Engineers Comments Regarding Surface Water Drainage

Application Reference:	WA/44/25/PL	Reviewer Reference:	ADC/EXT2/88
Planning Officer:	Harry Chalk	Date of Review:	14/01/26
Site Name:	Longacres Eastergate Lane Walberton BN18 0BA		
Application Description:	Erection of 1 No. self build dwelling with associated parking and landscaping (resubmission following WA/101/24/PL). This application is a departure from the Development Plan and is in CIL Zone 3 and is CIL Liable as a new dwelling.		
Assessment Number:	1 of 2

Reviewed Plans

PROPOSED DRAWING 2a
Site Plan
November 2024
1:200 at A3

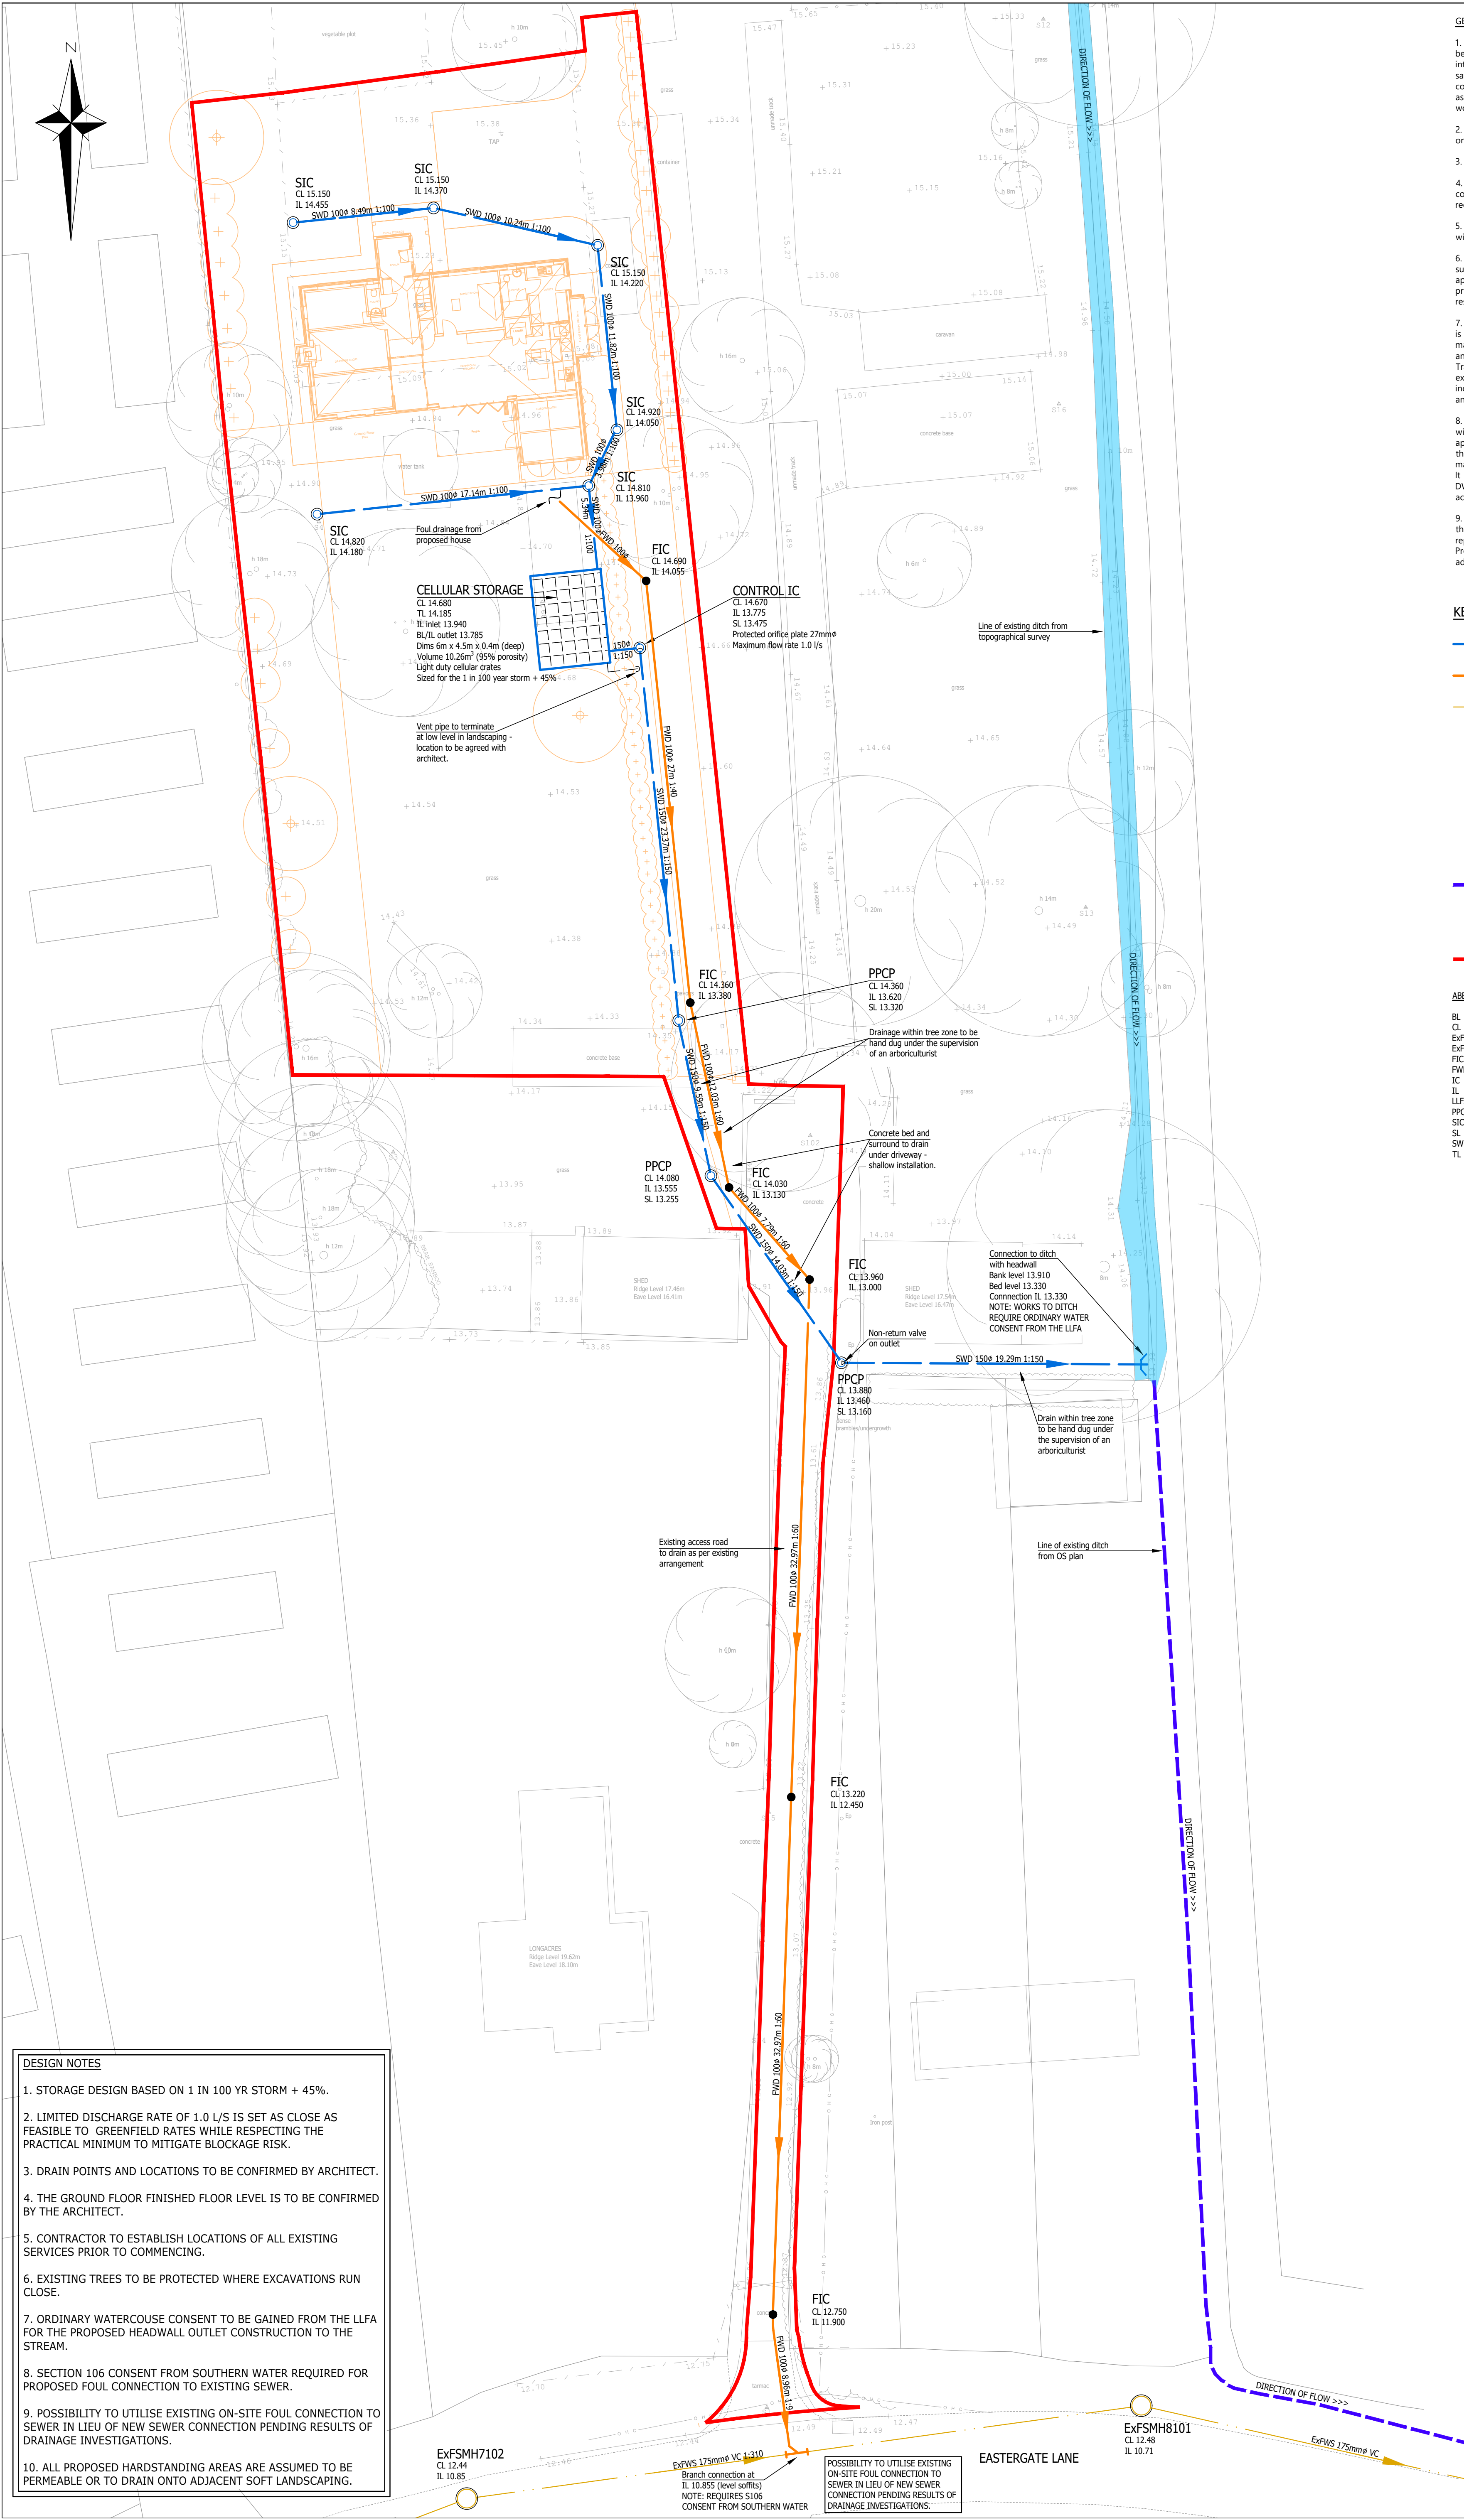
- 7.1. The root protection zones have been shown on the drainage strategy drawing and demonstrate that the proposed drainage does not encroach on them. Given the proximity of the proposed cellular tank to the existing tree T6, an assessment should be made regarding the need for a root barrier, this can be considered at a later stage under a discharge of condition application. Flotation calculations have not been submitted in respect of the cellular tank, this can be considered at a later stage under a discharge of condition application.
